City of Albuquerque Stormwater Construction Site Inspection Report

Project Name:	Homewood Suites		
Location:	5400 San Antonio		
Site Contact Name & Agency	Vinny Perumal / Ken Wilt	ESC File No.	E18E050
	Mountain west lodging	NPDES Id. No.	
Inspection Date:	02/14/19	Start/End Time:	0930/1000hrs
CoA Stormwater Inspector:	Timothy Sims, Stormwater Inspector		
Present Phase of Construction:	Interior framing		
Type of Inspection:	<input type="checkbox"/> Regular	<input type="checkbox"/> Storm Event	<input type="checkbox"/> Post Storm Event >0.25" <input type="checkbox"/> 311/Complaint <input checked="" type="checkbox"/> Follow Up

no.	date	remarks	by
REVISIONS			
	project title HOMESTEAD SUITES SAN ANTONIO NE ALBUQUERQUE, NM		
	sheet title SITE DETAILS		
	drawn by METO	design by JJB	project no. 1715
	sheet C1.2

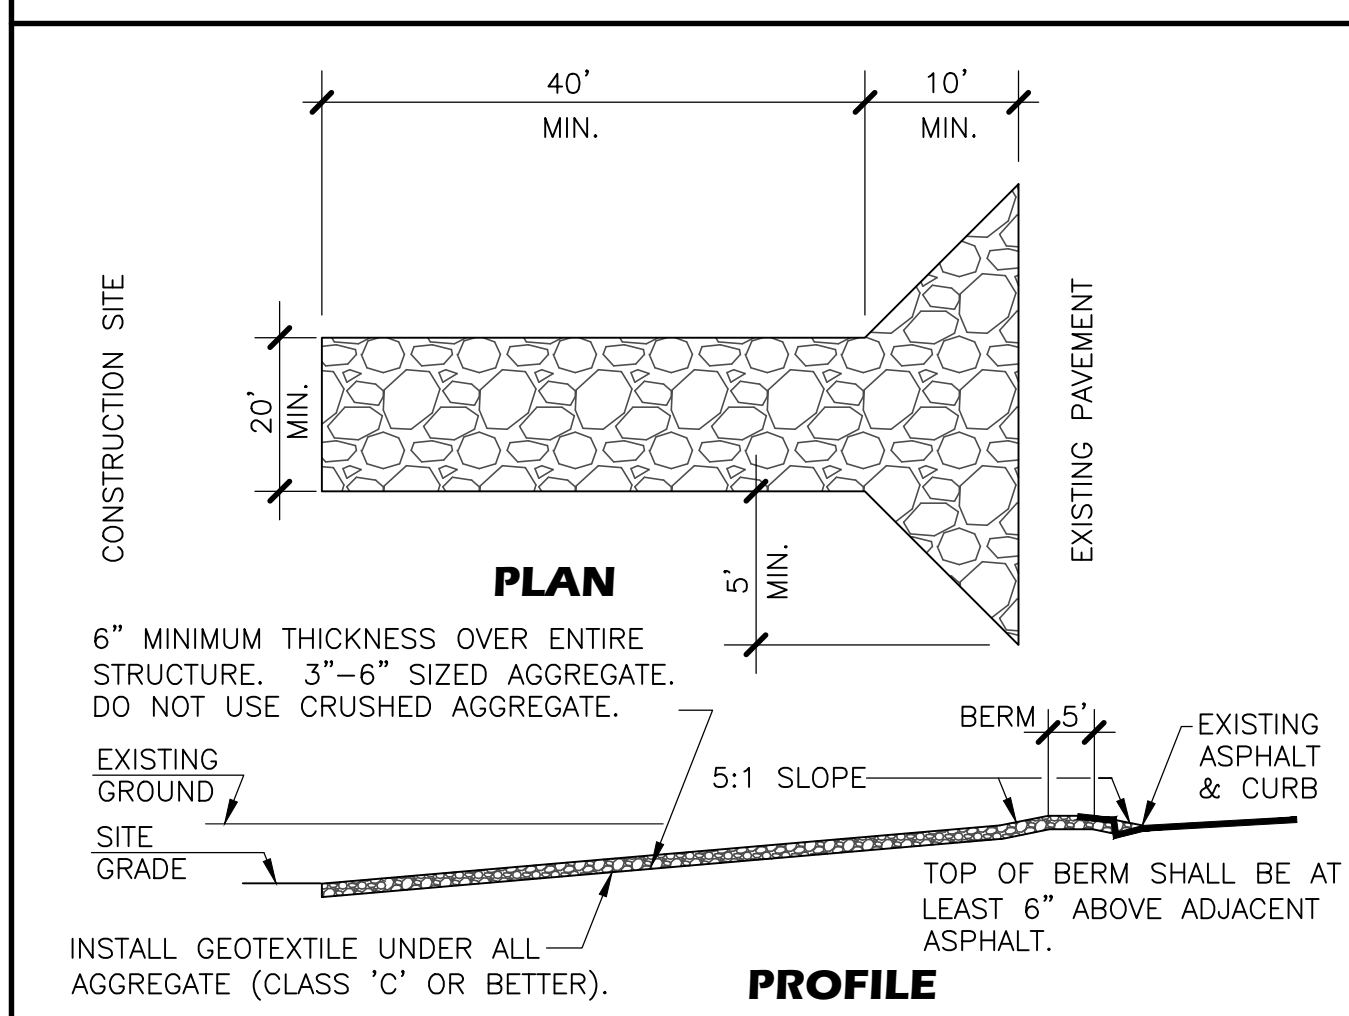
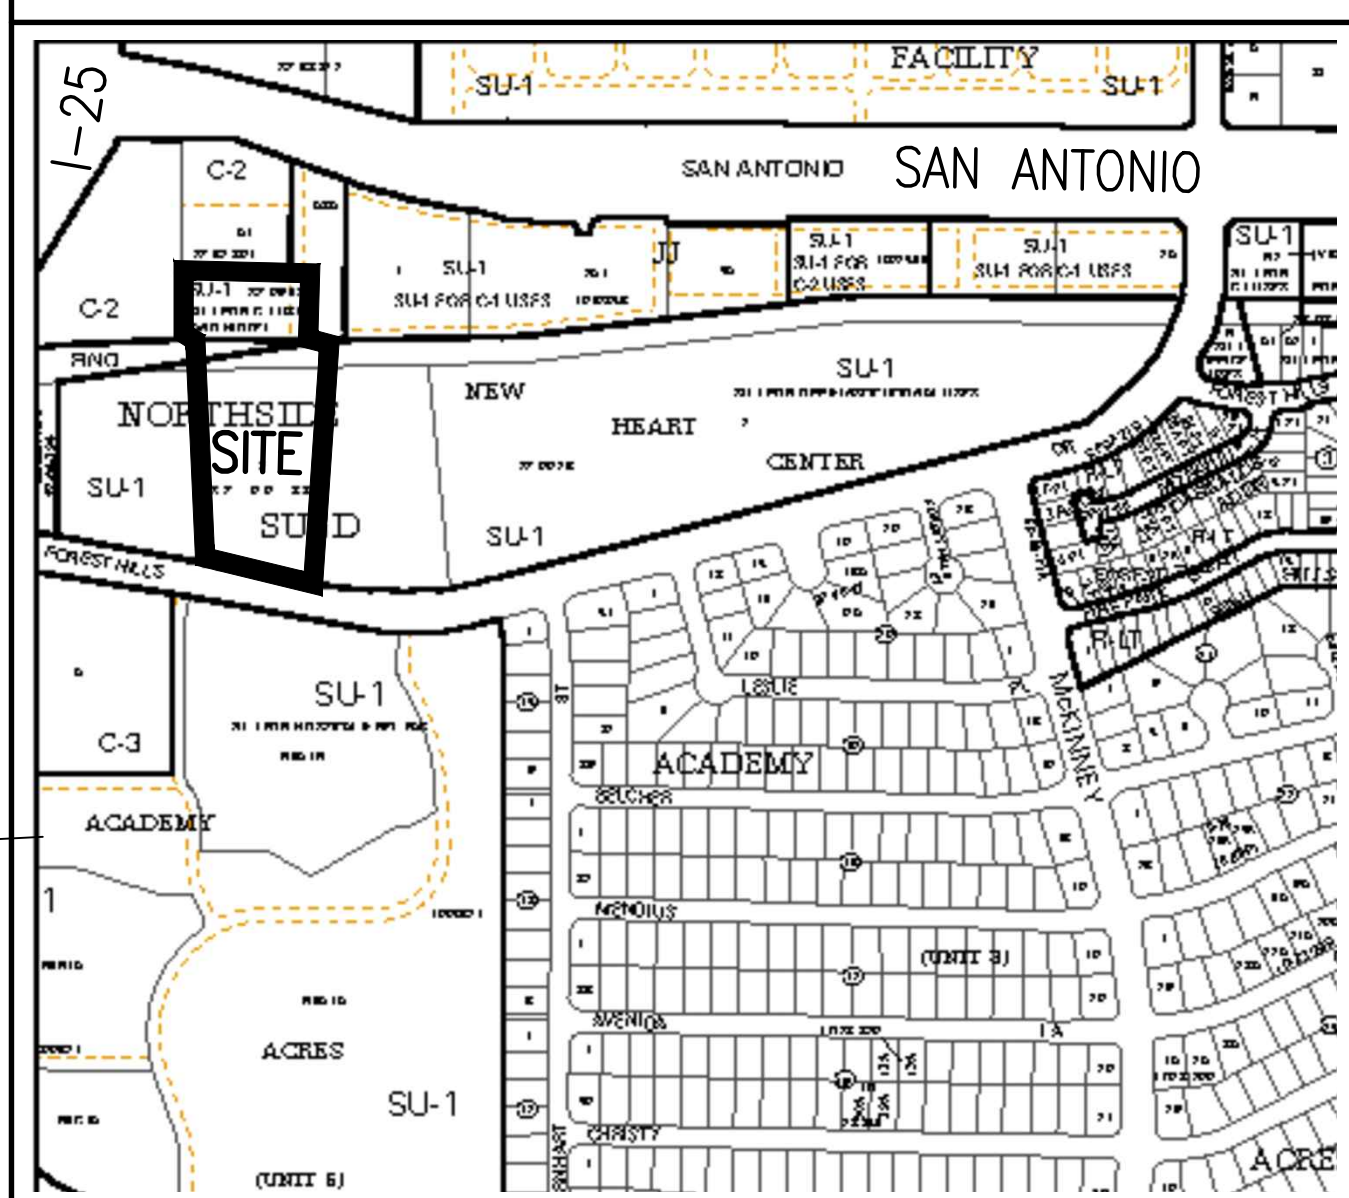
2.2.3	Sediment control along any perimeter	x	silt fence in SW corner of site needs repaired
2.2.3	Sediment control along any perimeter		
2.2.3	Sediment control along any perimeter

Maintenance or corrective actions are to be completed within seven (7) days.
